**From:** Biazar, Shahab  
**Sent:** Friday, July 18, 2014 2:56 PM  
**To:** 'David Soule'; 'Grant Morrison (grant@inspectionsplusinc.com)'  
**Cc:** Ortiz, Monica; Sims, Timothy E.; 'MBALASKOVITS@BHINC.COM'  
**Subject:** Dessert Hills of New Mexico, Erosion & Sediment Control Plan, G11E048

I have the following comment on the submittal for Dessert Hills of New Mexico, Erosion & Sediment Control Plan, G11E048.

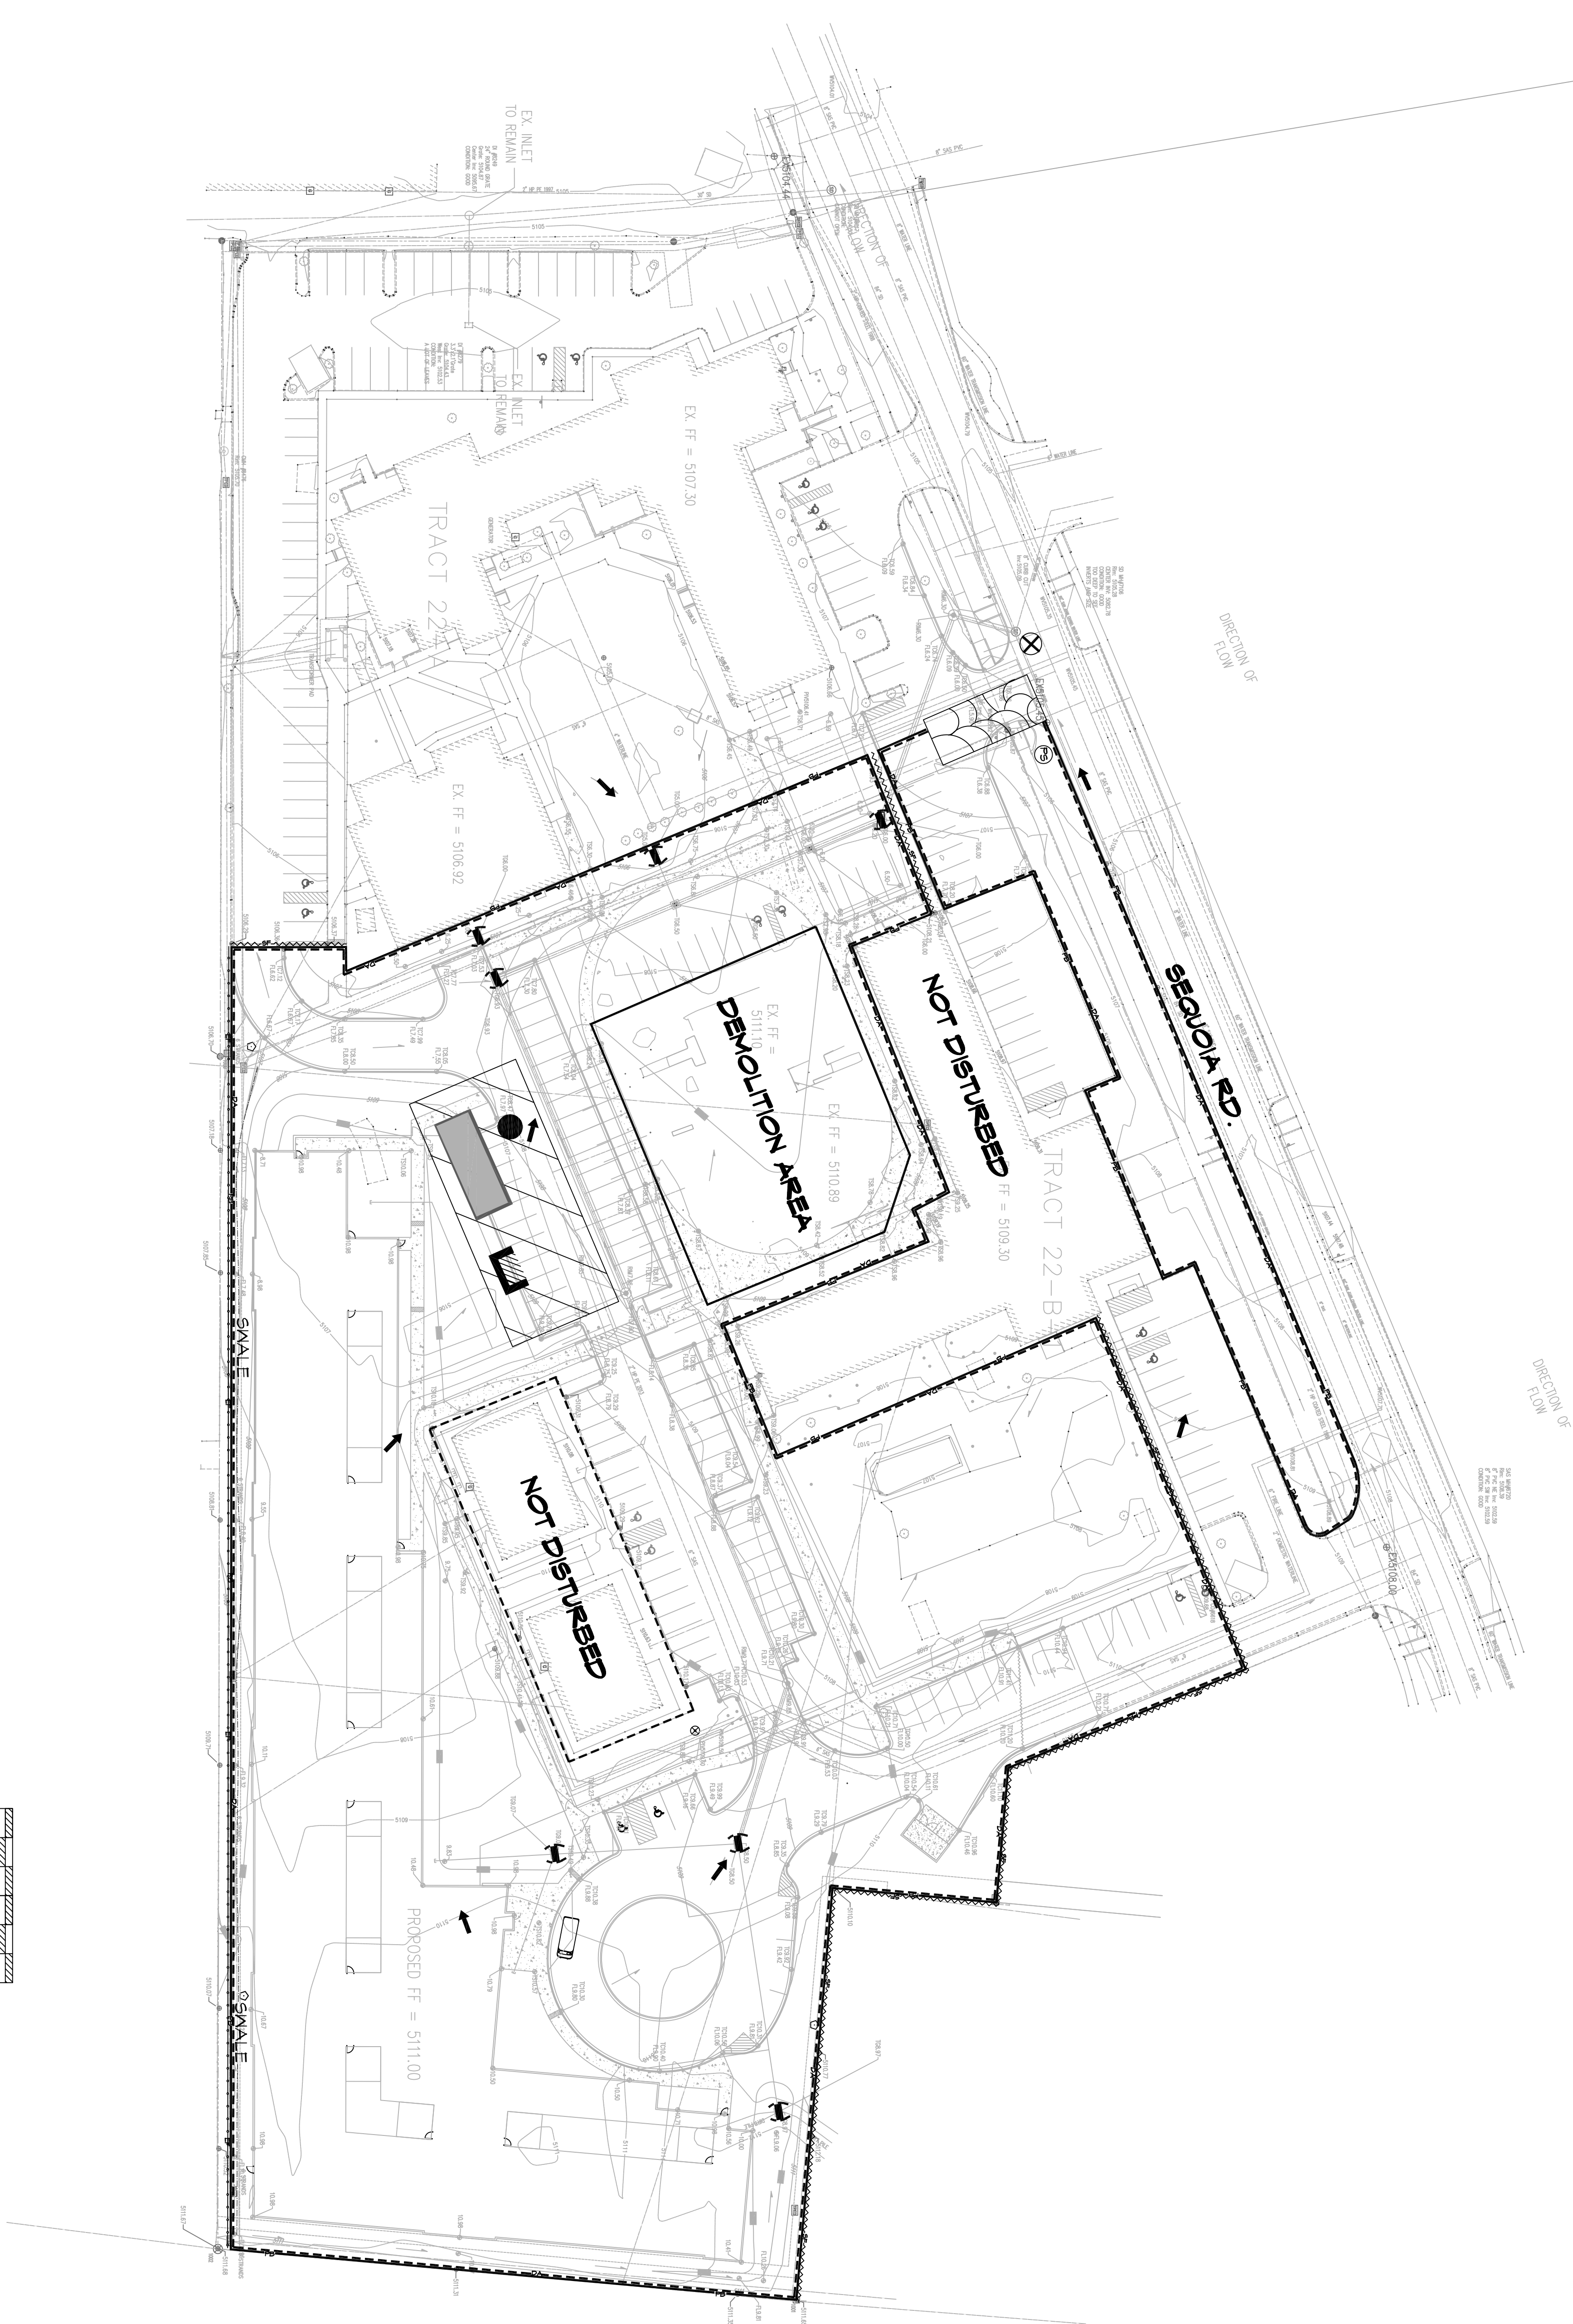
\_Provide a singed and stamped detail sheet (possibly the same stamp date as the plan 6/19/2014).
